HANNIGAN and ASSOCIATES, INC.

Re: Abert Ranch Subdivision
My Job Number: 16-009
Your P-17-005 & SP-17-007

This letter will respond to your Rezoning comment letter dated September 05, 2017 and your Preliminary Plan comment letter dated September 07, 2017.

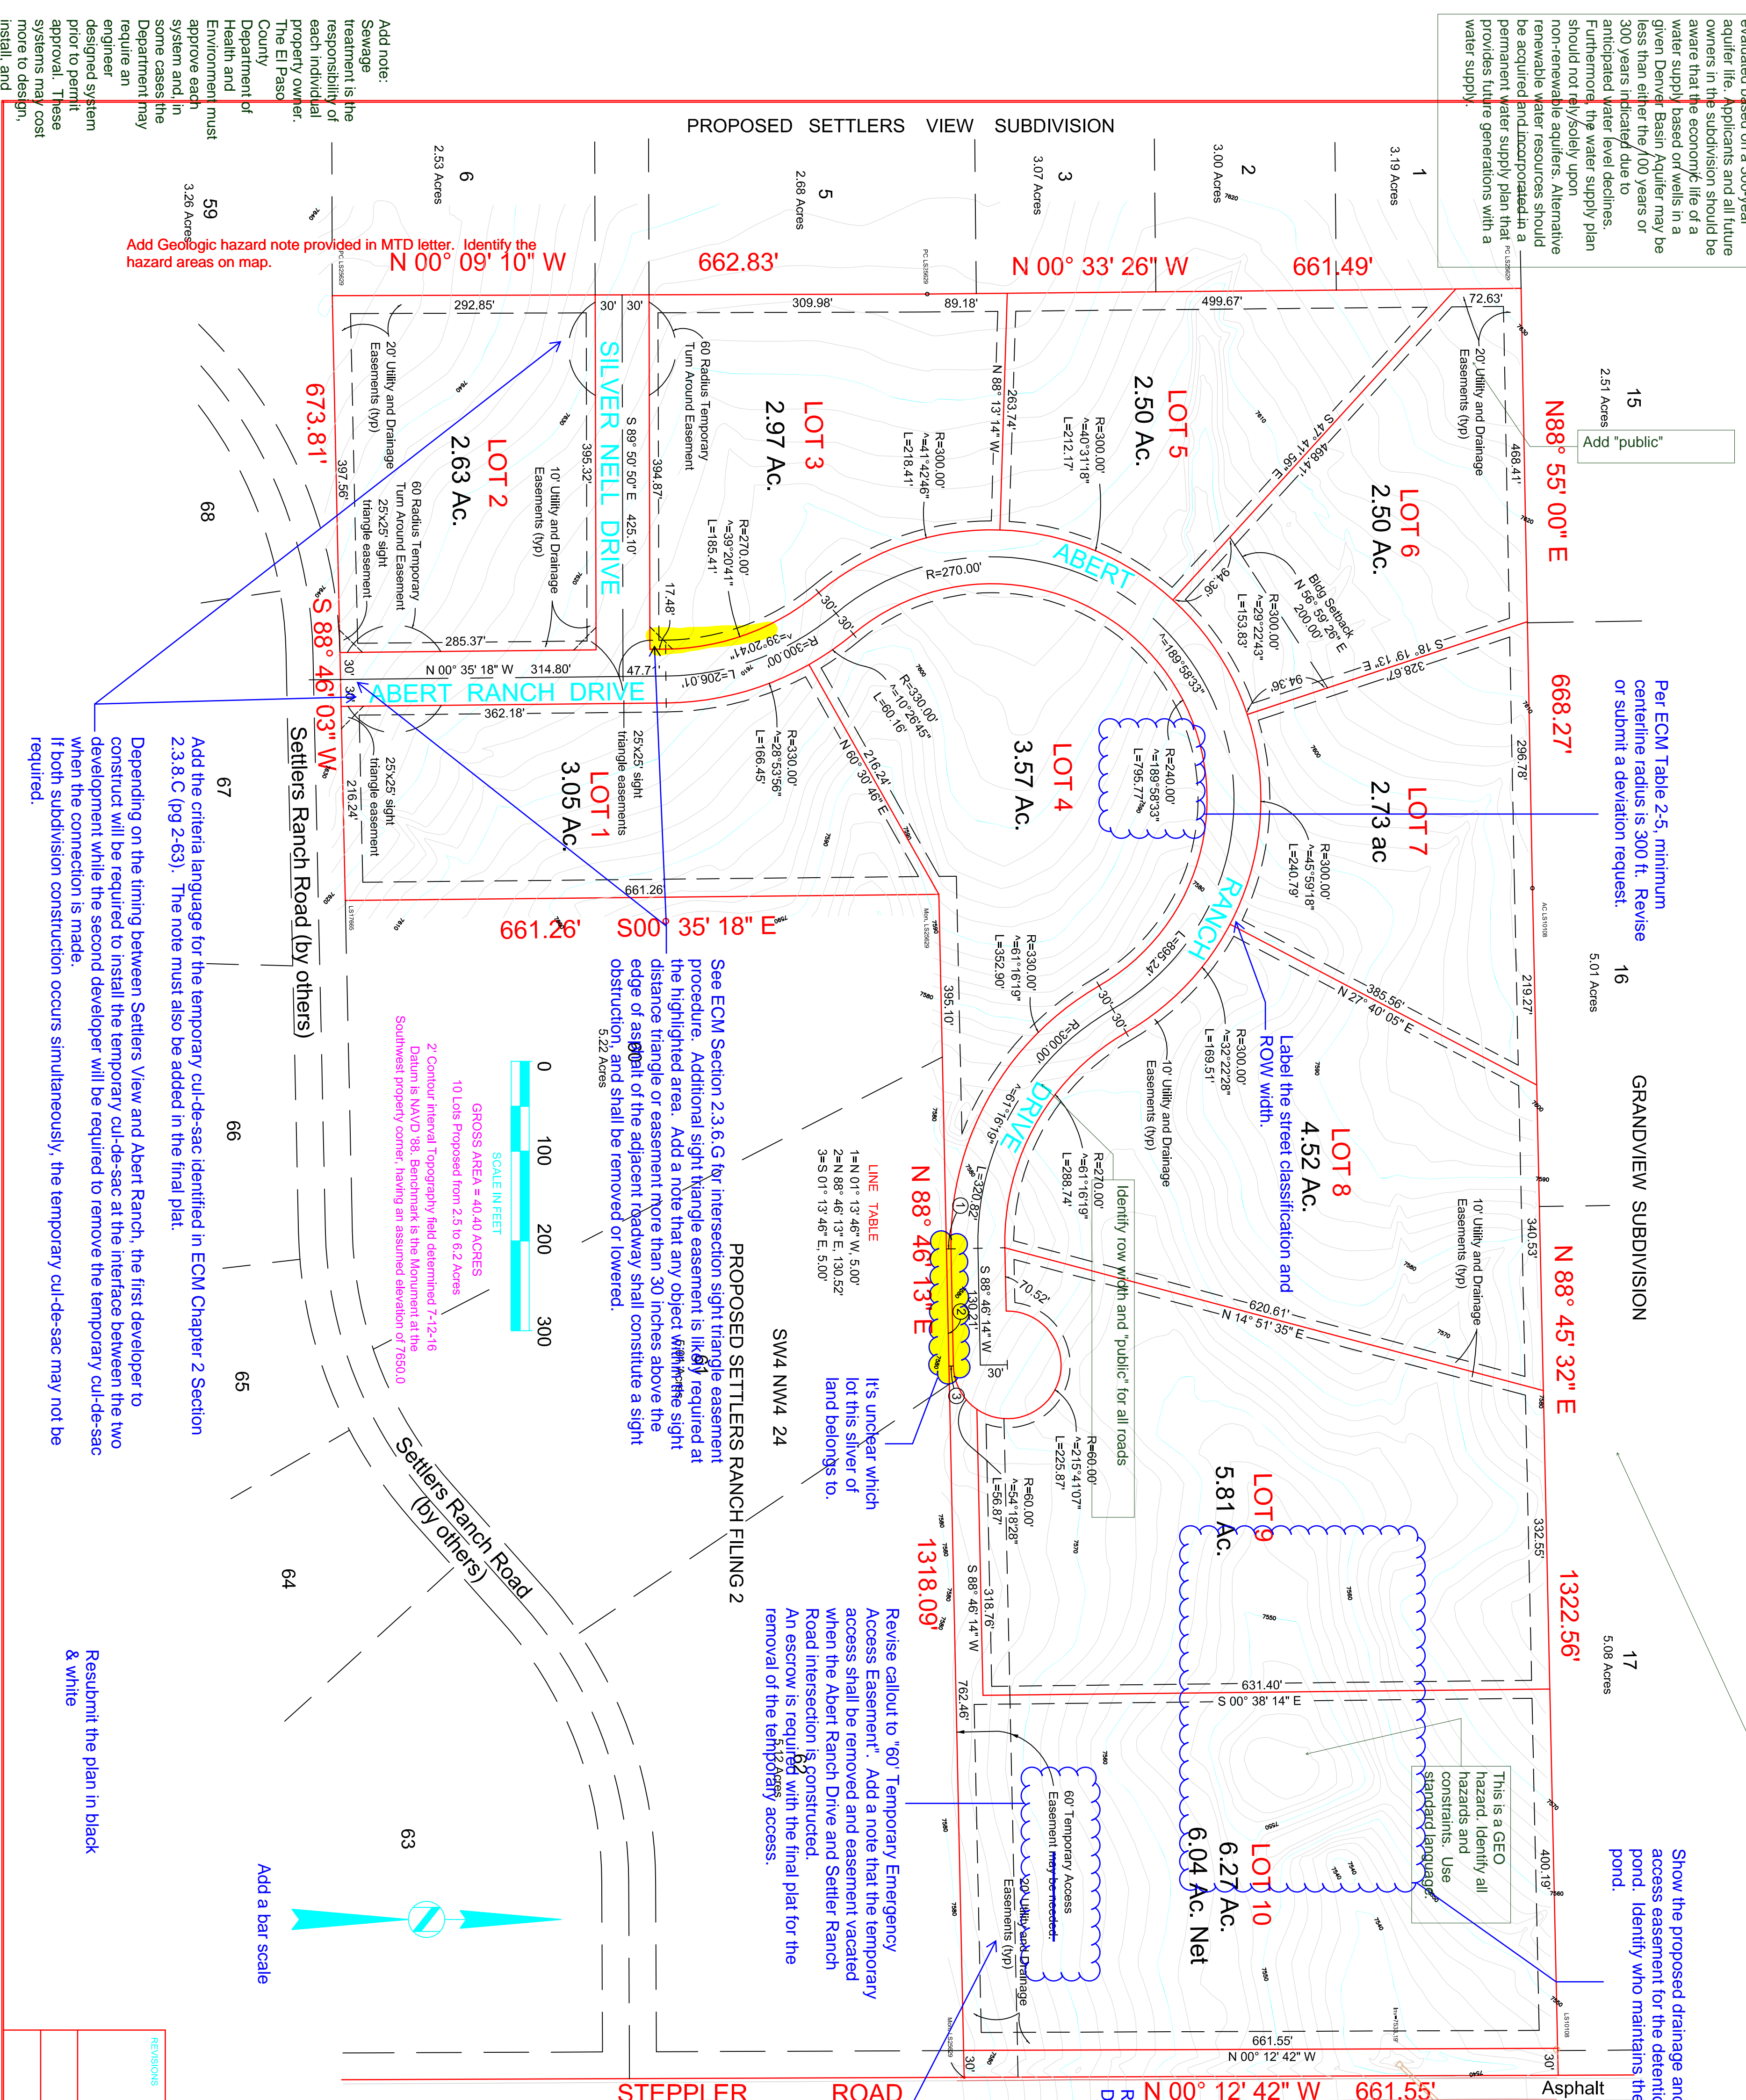
- 1.) Geologic Hazard note added. The report did not locate expansive clayey sandstone and claystone nor conditions favorable to perched groundwater. Those areas not mapped are mentioned in the note as possible anywhere.
- 2.) Areas depicted.
- 3.) No septic suitability map was provided. Constraints are noted as possible on any lot and each proposed leach field area must be individually tested.
